From: Sarah Burrow <Sarah.Burrow@arun.gov.uk>
Sent: 10 July 2020 17:04
To: Planning.Responses <Planning.Responses@arun.gov.uk>
Cc: Maria Tomalova <Maria.Tomalova@arun.gov.uk>
Subject: RE: Planning Consultation on: Y/53/20/DOC

Engineers Comments Regarding Surface Water Drainage

Application No: Y/53/20/DOC
Registered: 17th June 2020
Site Address: Yapton Metal Company Burndell Road Yapton BN18 0HP
Description of Works: Approval of details reserved by condition imposed under ref Y/53/20/DOC relating to Condition Nos 3 - surface water drainage, 4 - SuDs and 6 - hard & soft landscaping.

Drawing Title
**SURFACE WATER
DRAINAGE STRATEGY**

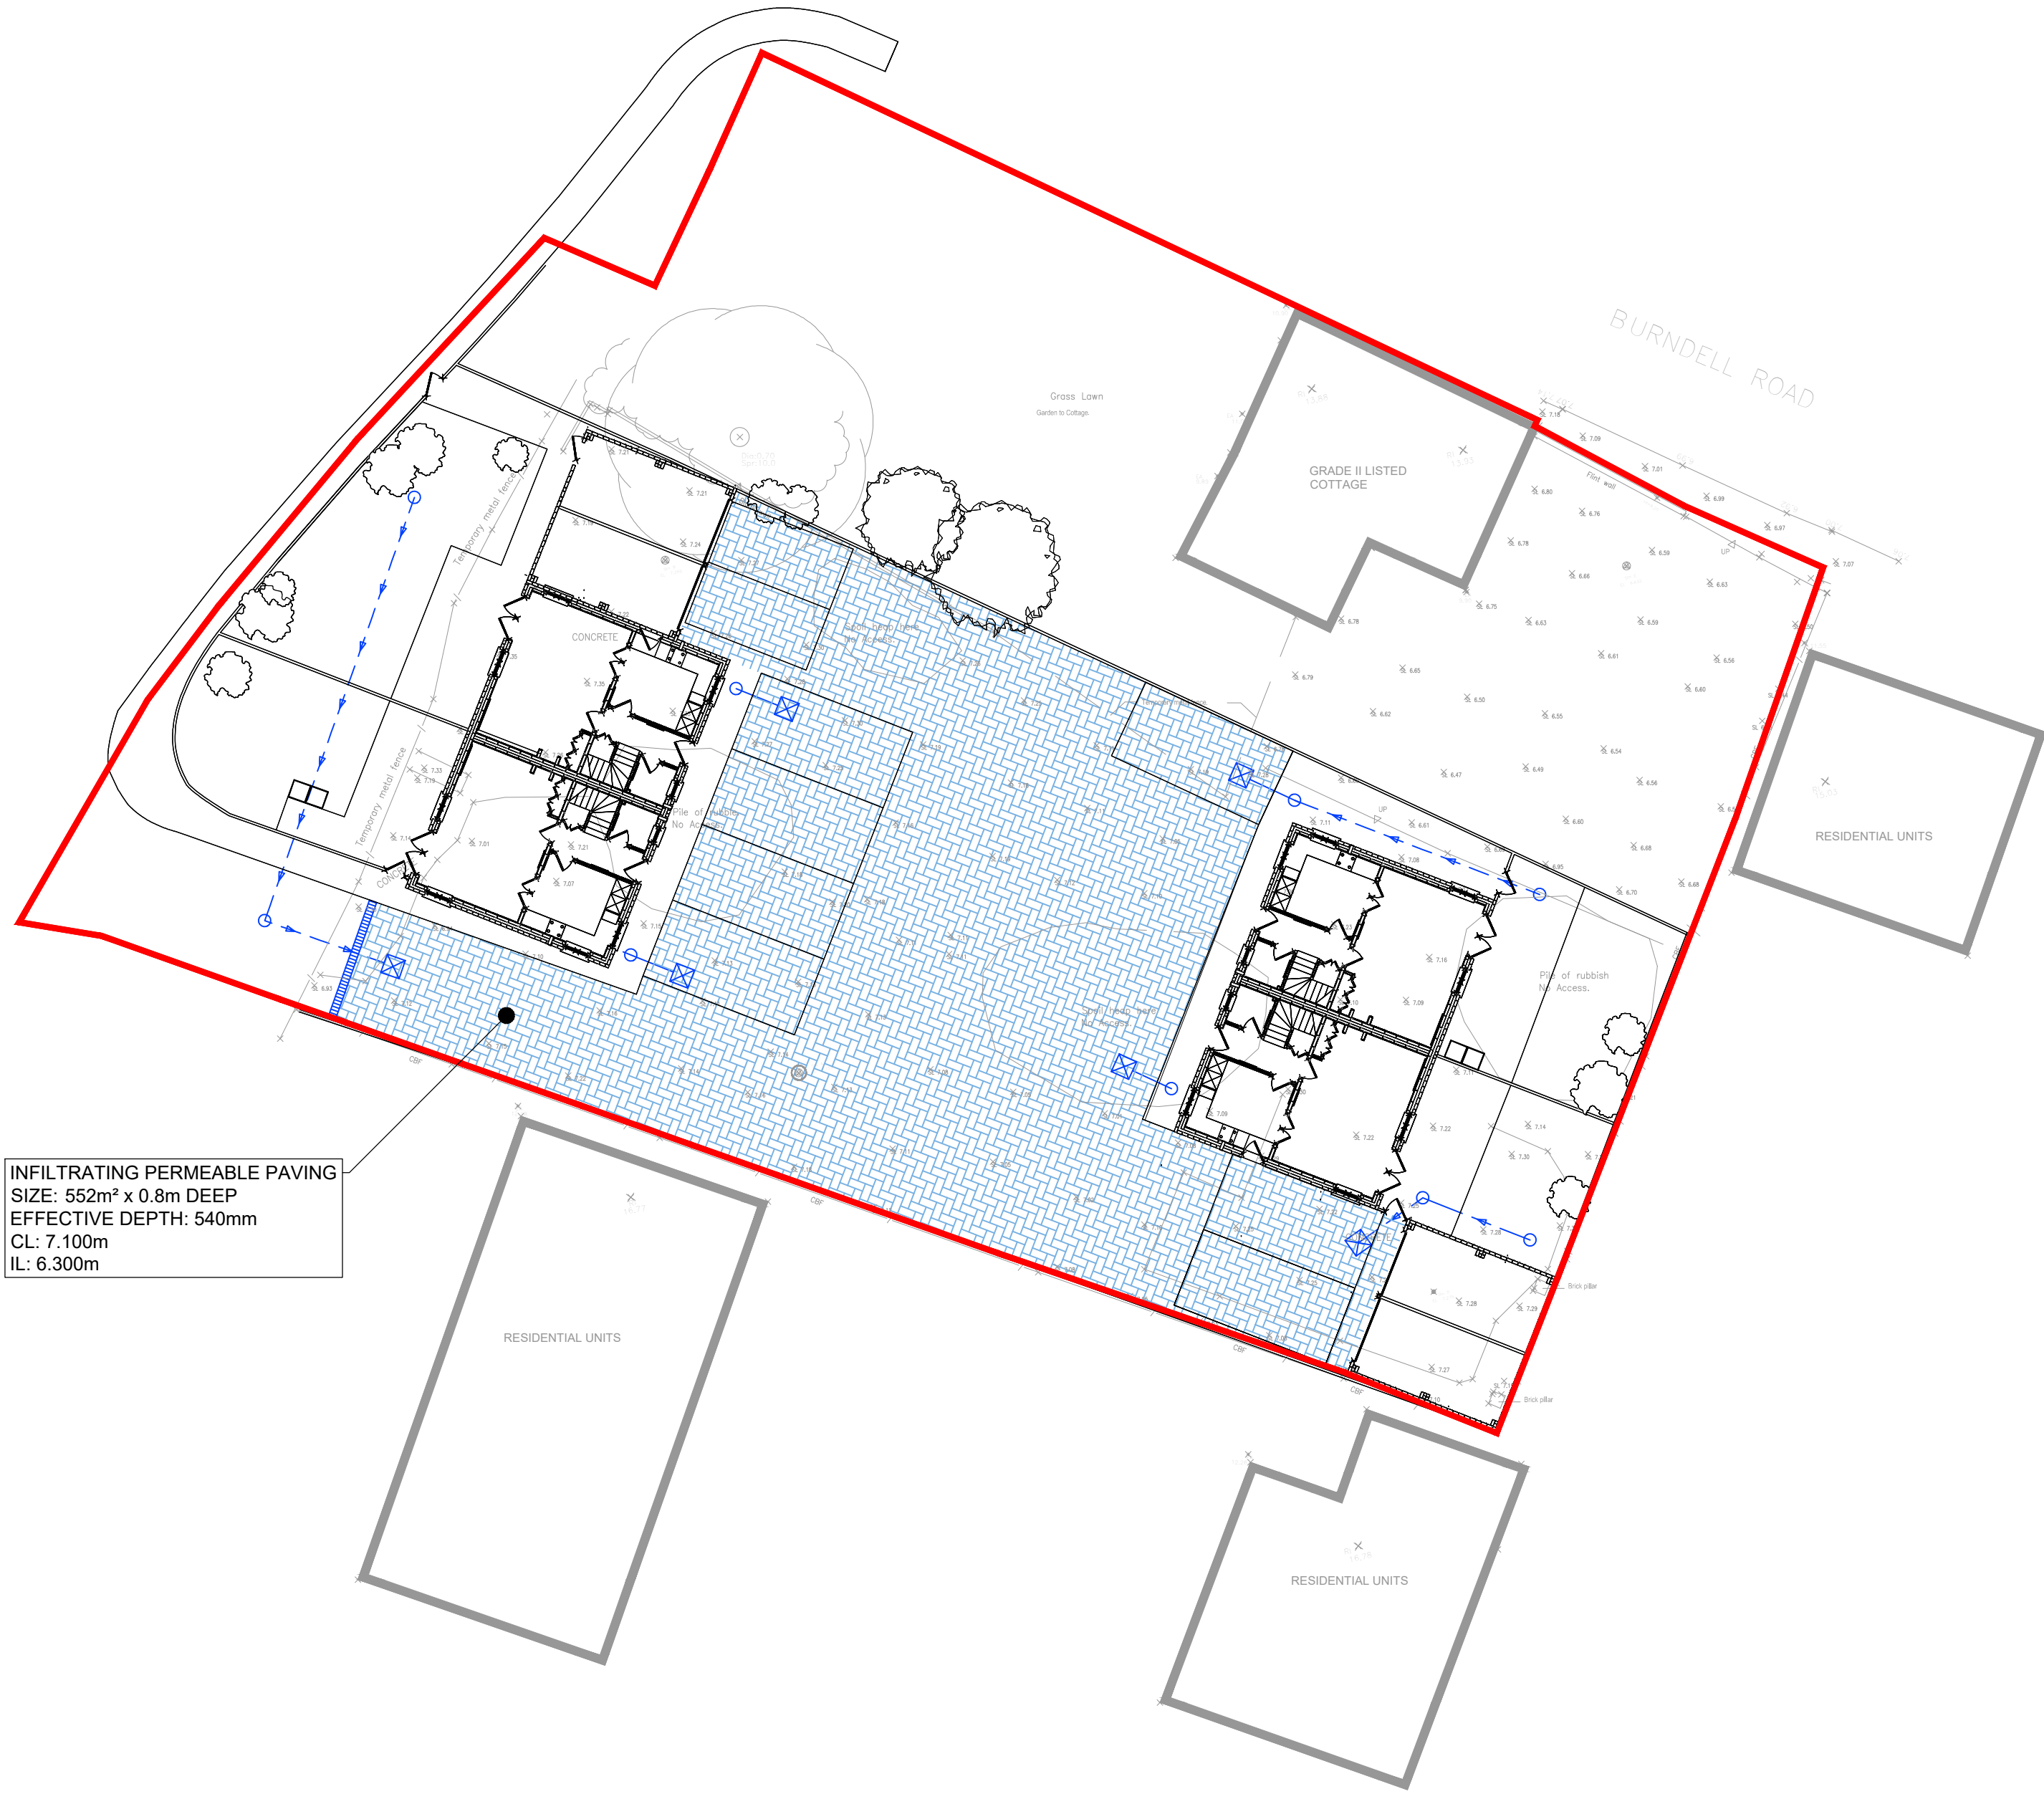
1. The cover letter states that "It is also understood that the replacement of areas of block paving with landscaping and asphalt, as shown on the combined landscape and drainage plan is acceptable." Please can the applicant/agent advise who stated this was acceptable?
2. The Drainage Layout requires the following further detail;
 - a. All surface water pipes should be labelled with; diameters, materials, falls and invert levels (at each end). (If all pipes are the same diameter and material a note to that effect is acceptable).

- b. All manholes/inspection chambers/silt traps should be labelled with cover levels, invert levels and cover types.
 - c. It is expected that all inspection chambers upstream of the permeable paving are sumped (silt traps).

- d. Diffuser units should be 5m from any buildings.
3. A Class Z pipe bed and surround construction detail is expected for the pipe running under the road.

4. Please specify "no fines" for the permeable paving sub base.
5. It was clearly stated in my last correspondence that we would not approve an overland flow route to Burndell Road due to the existing flooding issues there. I instructed the engineer to try and find a solution which holds all the surface water on the site without blocking access for future residents. No change has been made to the overland flow route which still goes to Burndell Road. Given the half drain time for this design we are not prepared to accept this solution.
